Drafted 6 July 2012

**Planning Application, Ribble Valley District
3/12/0509 19 Clitheroe Road, Whalley**

Drawing No.
12 | 108 | 001

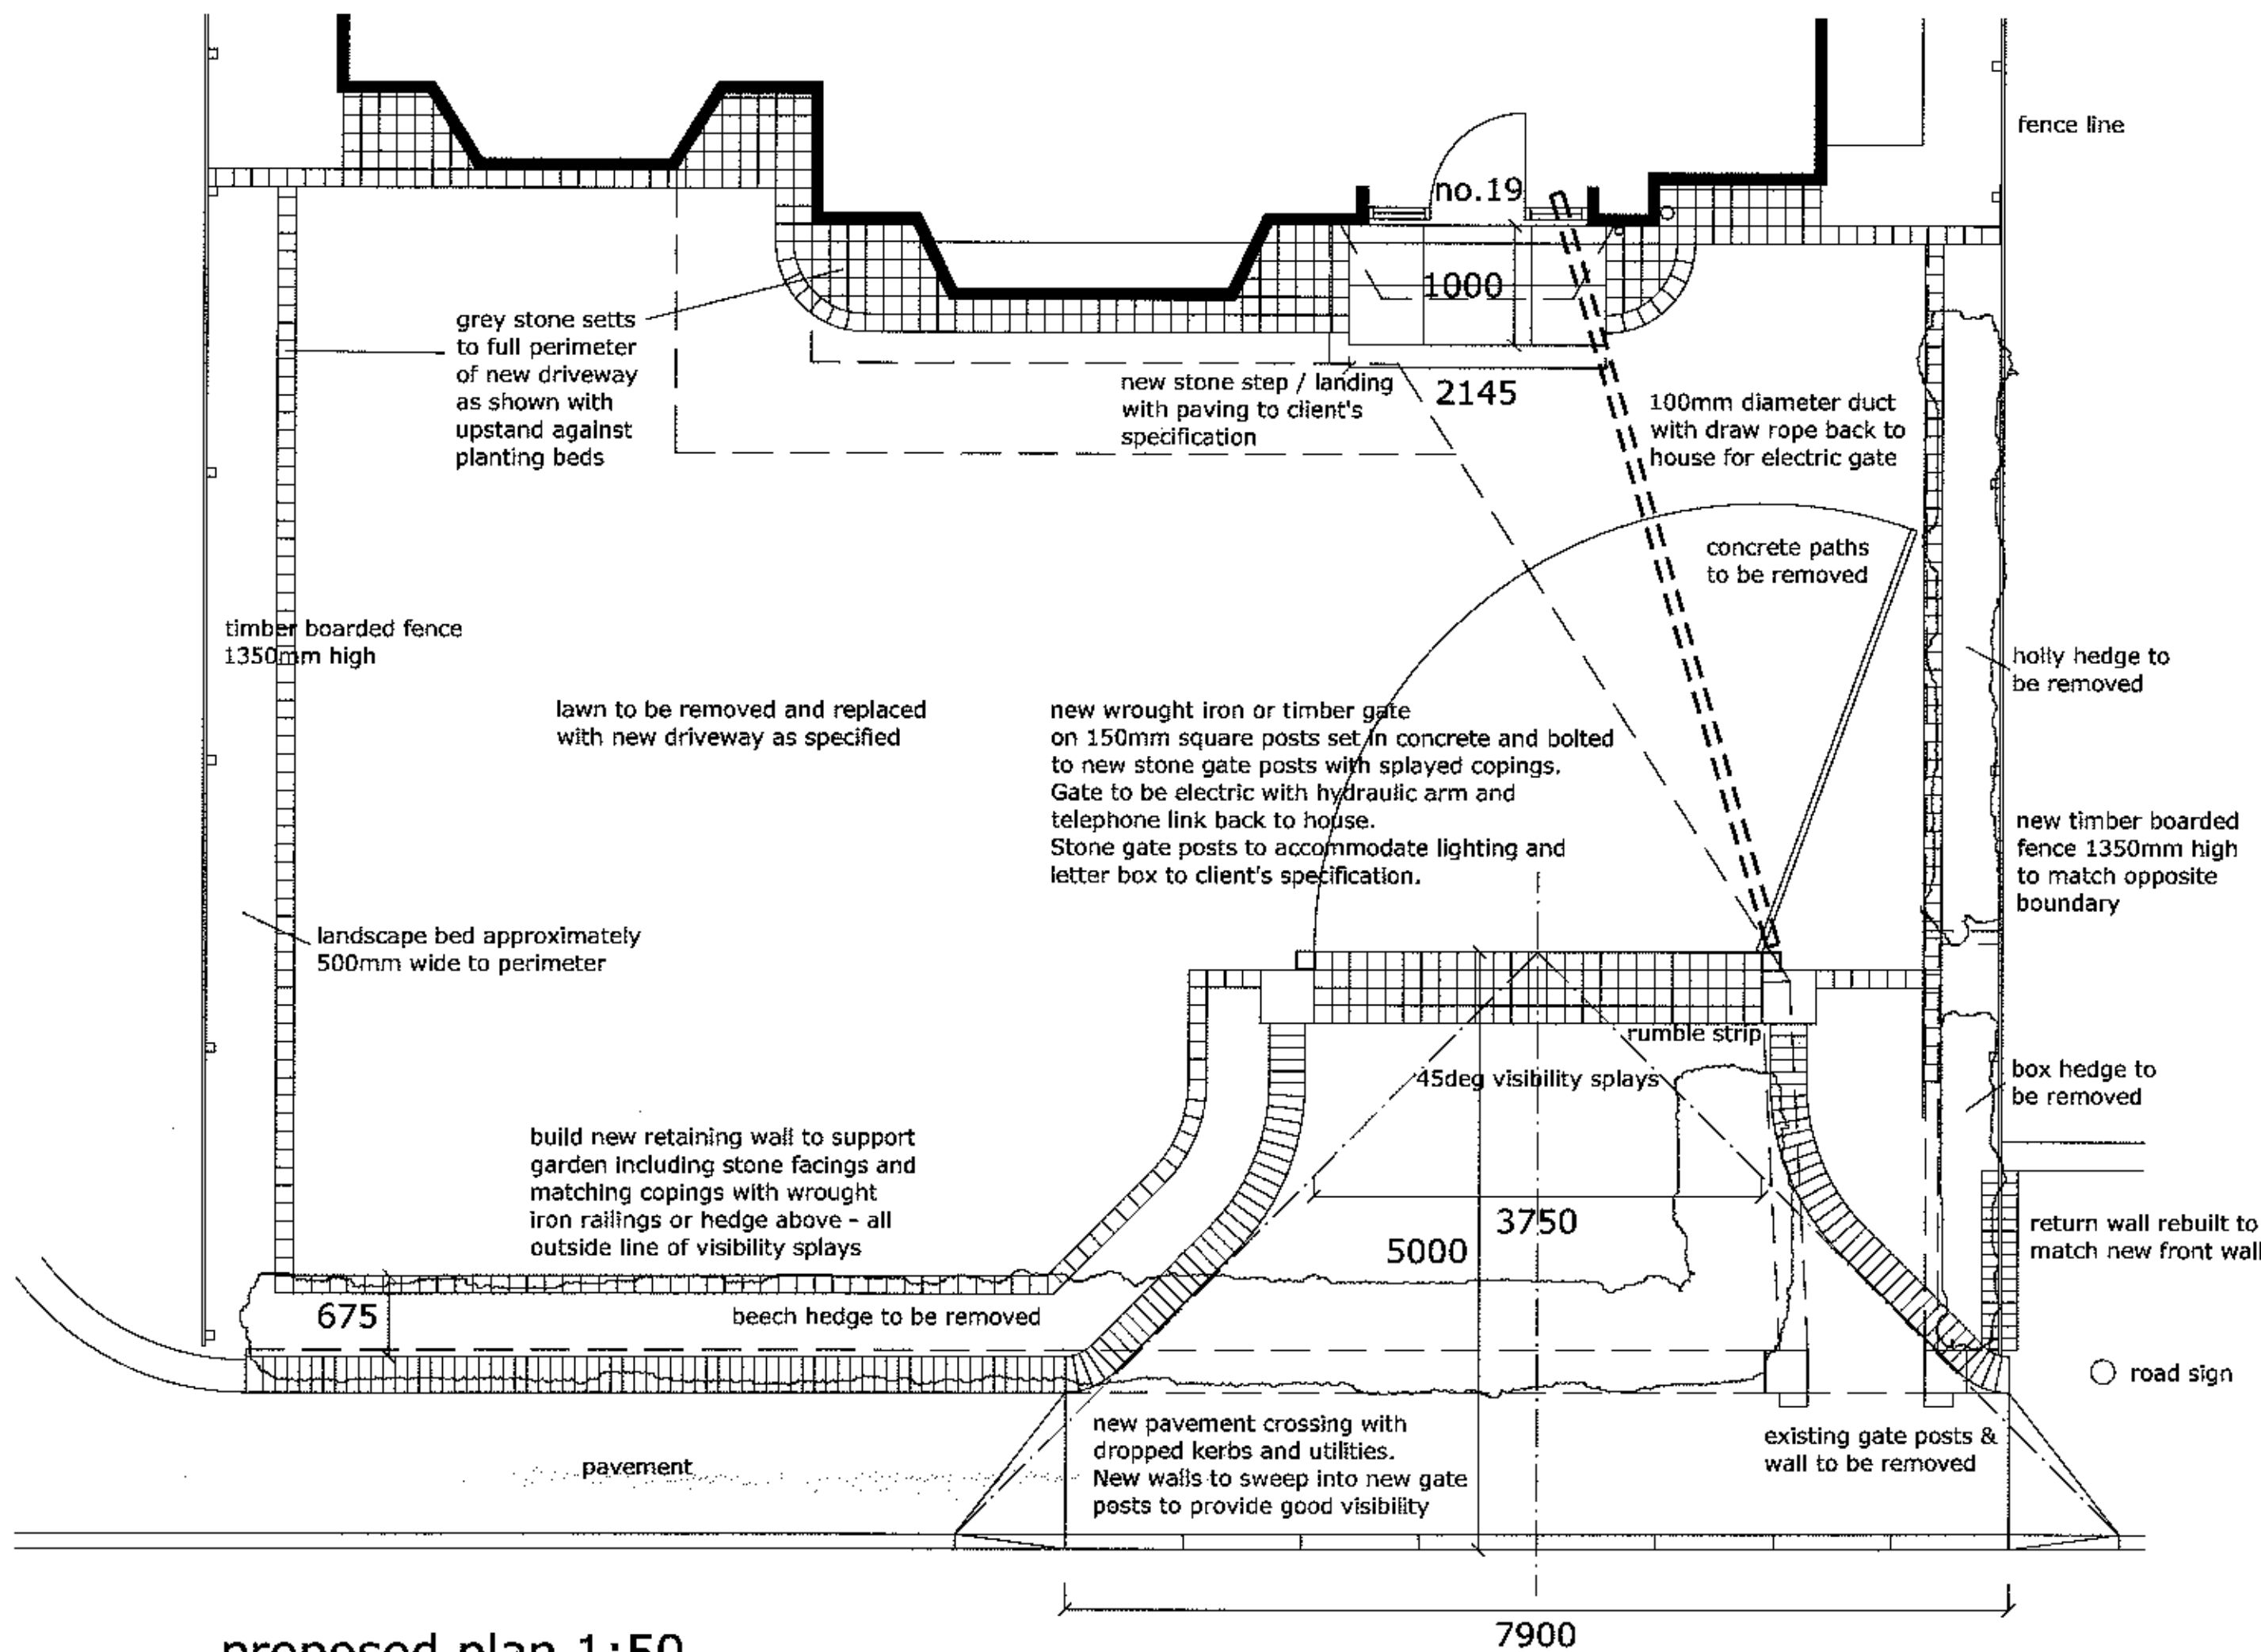
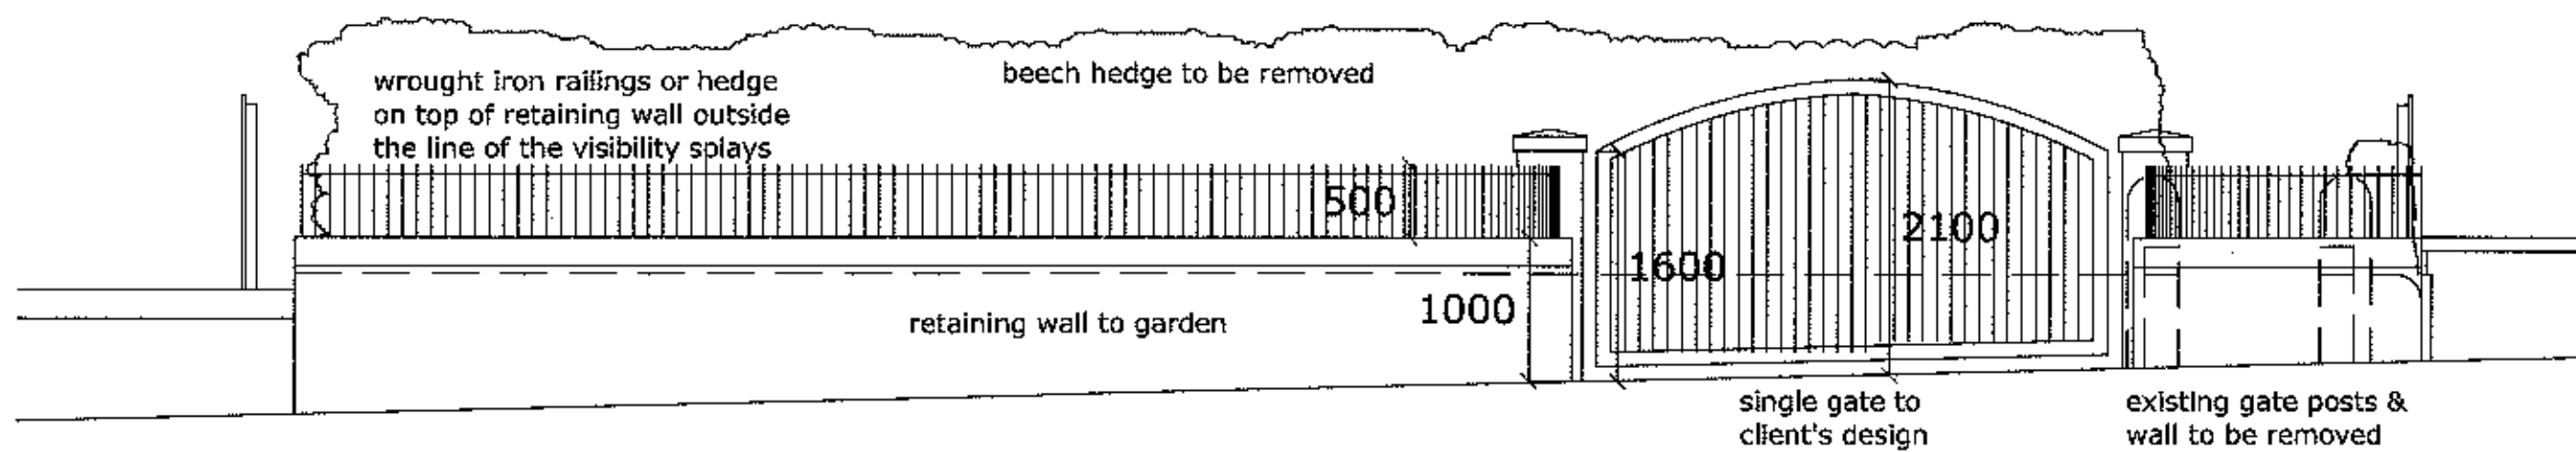
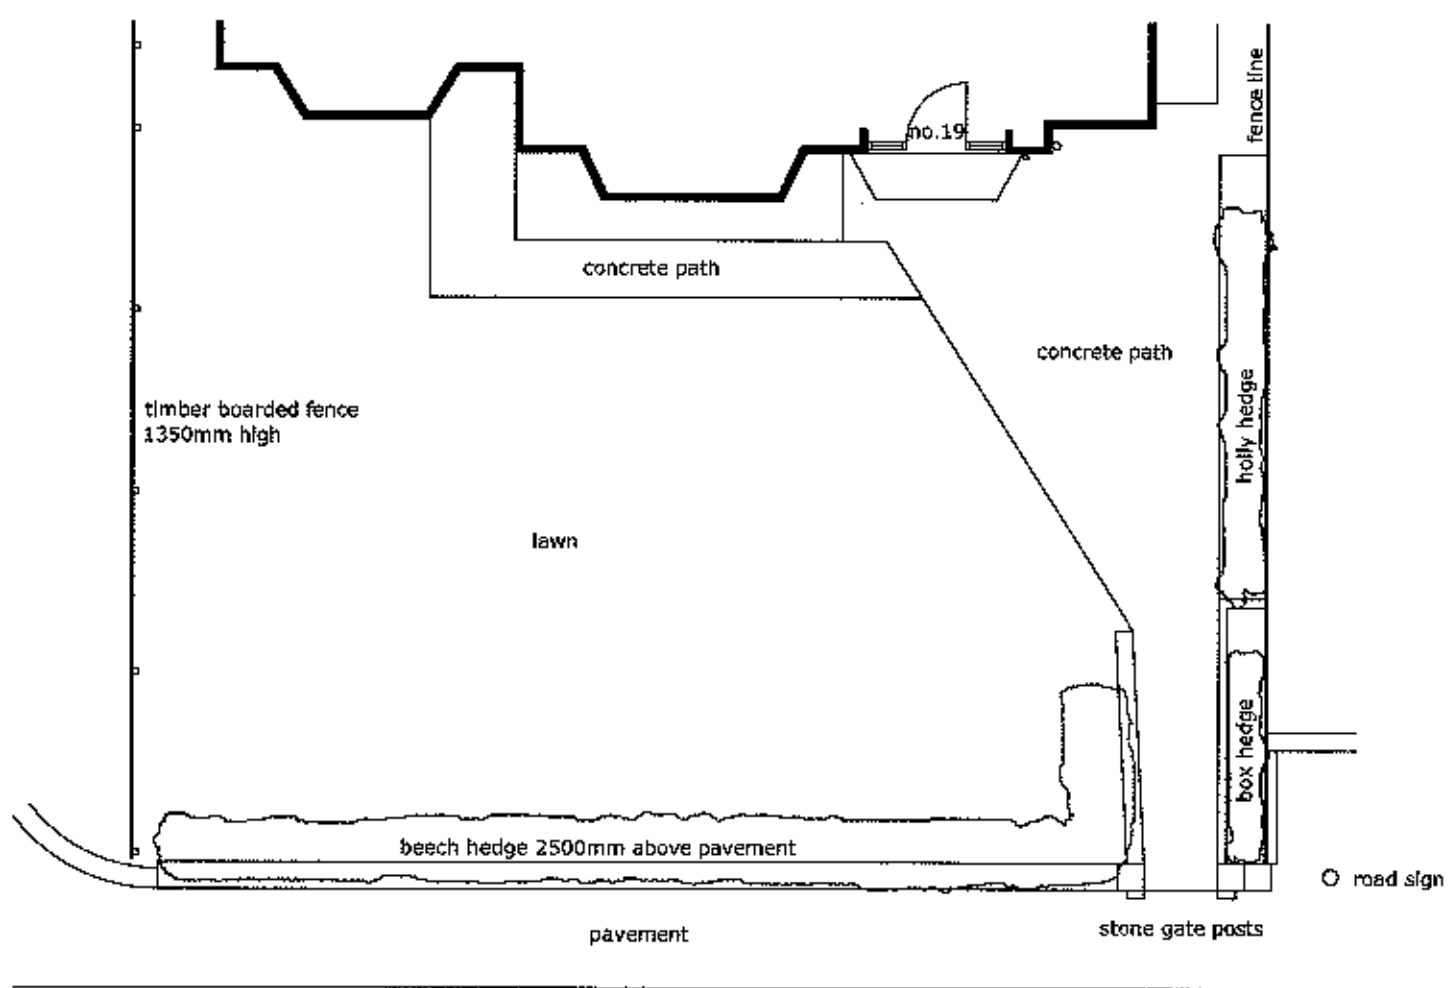
However, the layout for the driveway access and the location of the proposed gate does not comply with LCC recommendations, as detailed below.

In addition, the boundary wall that defines the visibility splay appears to be topped with additional fencing. An amended site plan should be provided that confirms that this impediment to visibility is removed from the final drawing, should consent be granted.
